CITY OF ALBUQUERQUE

**Re: Townhouse Project AJR Development, 12,004 Zia Road NE,
Traffic Circulation Layout (DRB 1005236)
Architect's Stamp dated 4-12-13 (K-22-D022D)**

ENGINEER'S SEAL 	ZIA PARK HOMES GRADING AND DRAINAGE PLAN Rio Grande Engineering 1806 CENTRAL AVENUE SUITE 201 ALBUQUERQUE, NM 87106 (505) 872-0999 MAY 2013	DRAWN BY WCMJ DATE 5-07-13 2721-LAYOUT-2-05-13 SHEET # JOB # 2721
---------------------	--	---

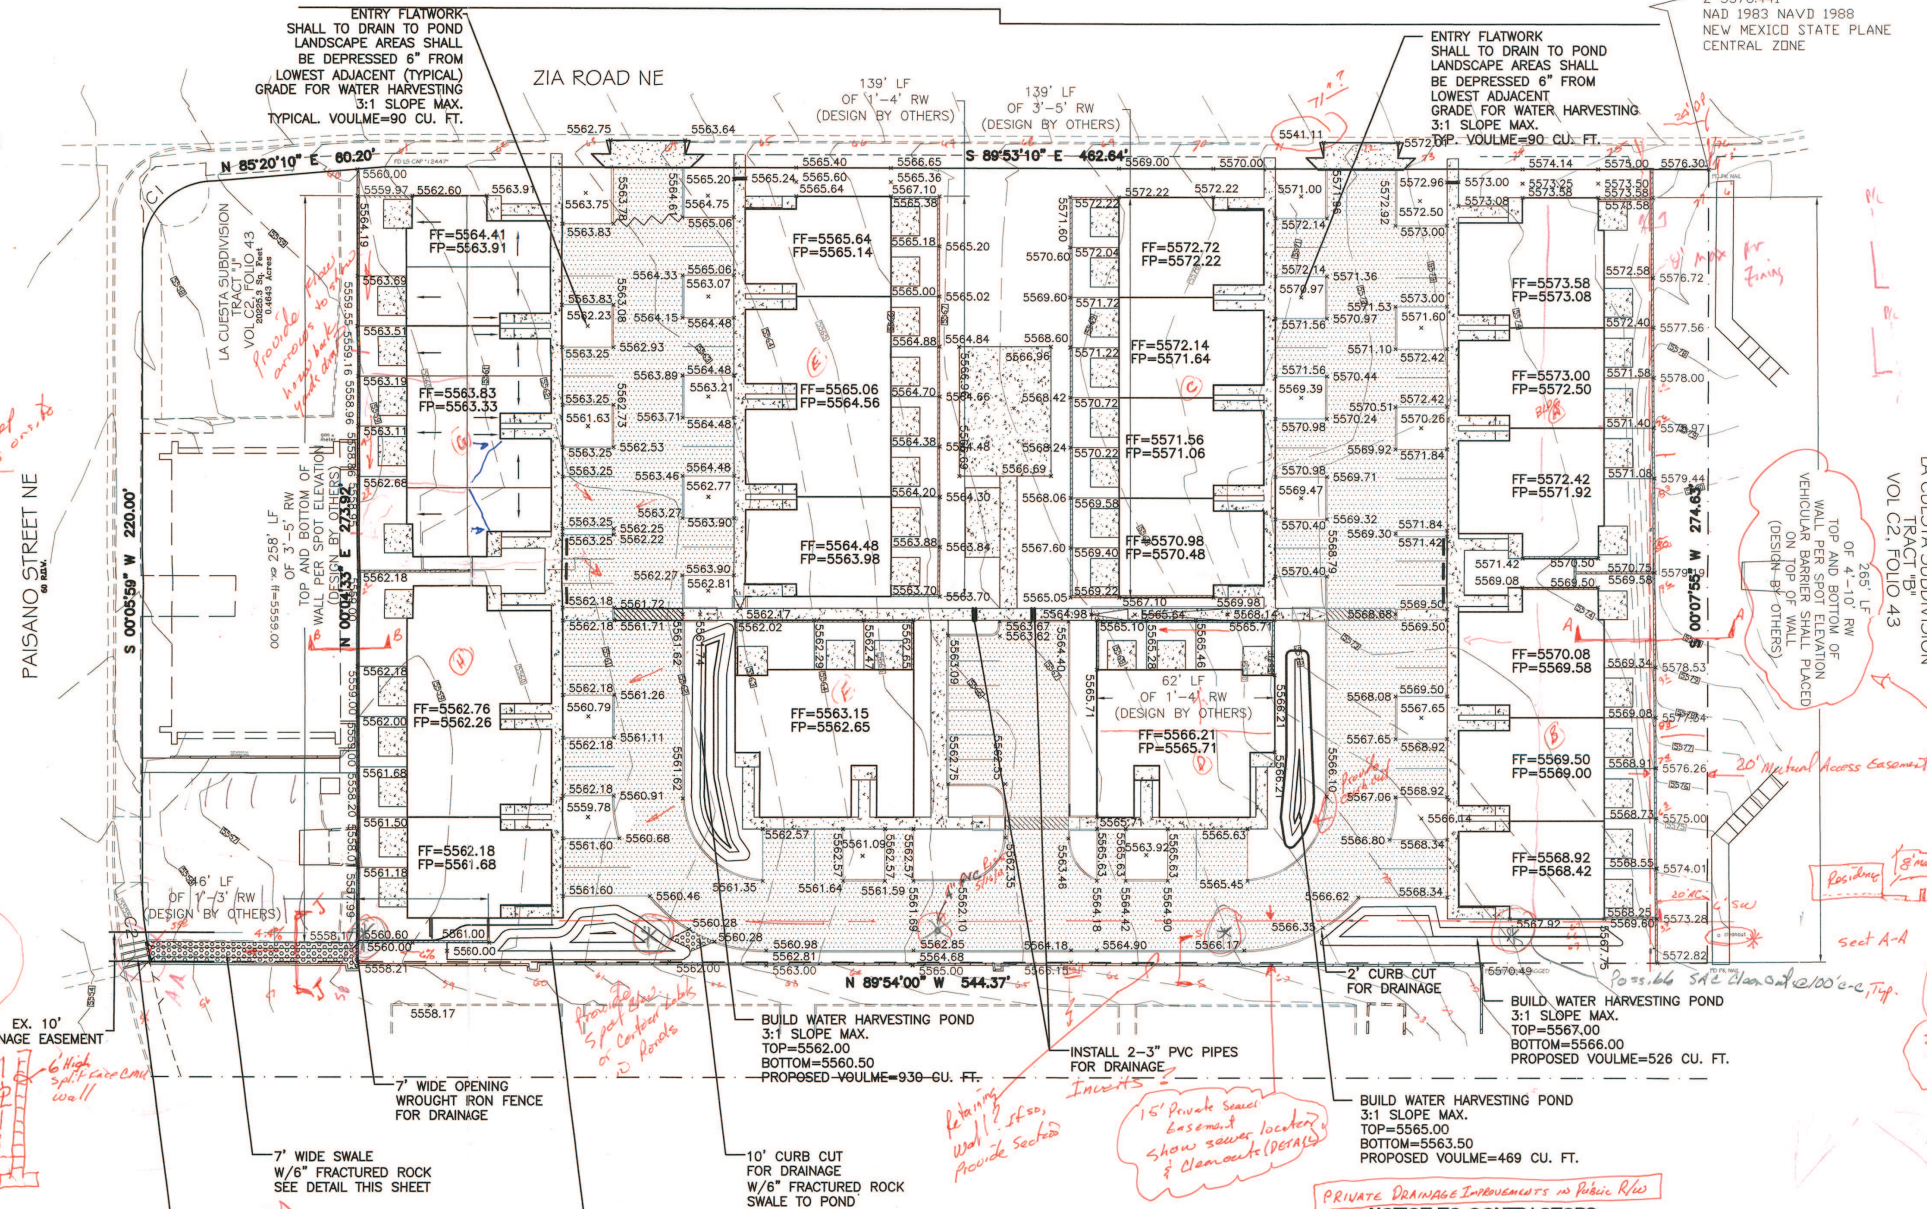
1. The preliminary plat (DRB 1005236) must be approved prior to Building Permit approval.
2. Please provide details of proposed curb and gutter, including landscape curb (Keyed note 7) adjacent to the asphalt paved access road or reference COA standard drawings.
3. Please include a note that the landscaping adjacent to turnouts and driveways will maintain the 11 foot clear sight triangle per DPM standards.
4. Please refer to all applicable city standards.
5. Please ensure all ramps are ADA compliant.
